GRANT HAYS ASSOCIATES

DATE: May 17, 2016

RE: Foundation Brewing Company Expansion
Permit Review Comments

SHEET  
**A4**  
COPYRIGHT  
REPRODUCTION OR RELIANCE OF THIS  
DOCUMENT WITHOUT WRITTEN  
PERMISSION FROM GRANT HAYS  
ASSOCIATES IS PROHIBITED.

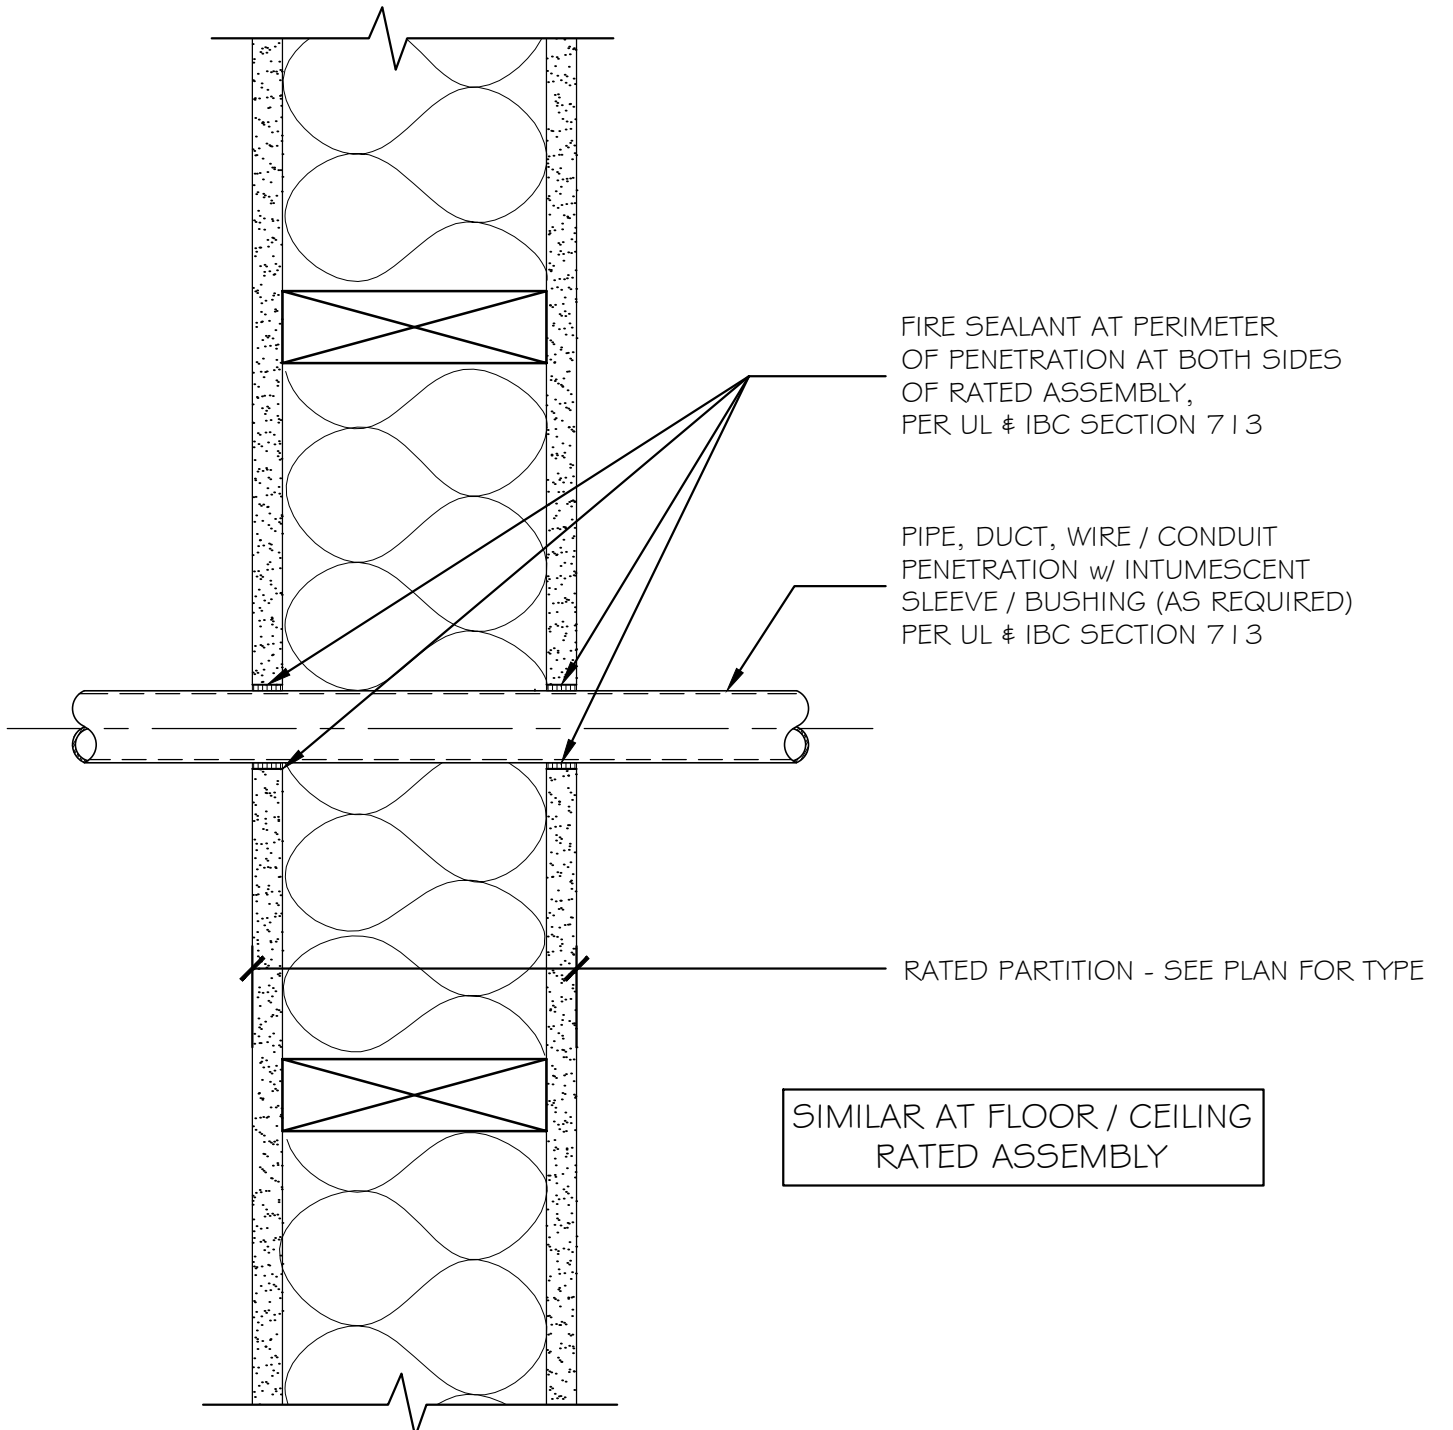
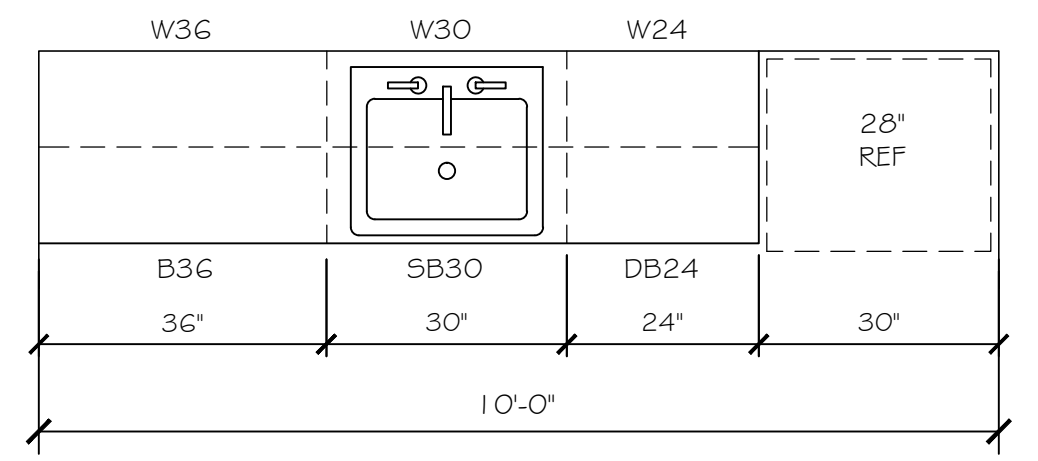
7. See new Sheet A7 for fire rated assembly wall details, as well as Sheet A4 & A5 revised partition/floor assembly details for firestopping.
8. Attached is the revised Code Analysis requested by Michael White indicating the 2009 NFPA 101 (required by Portland) listed criteria is the same for the 2012 edition (required by Maine FMO).
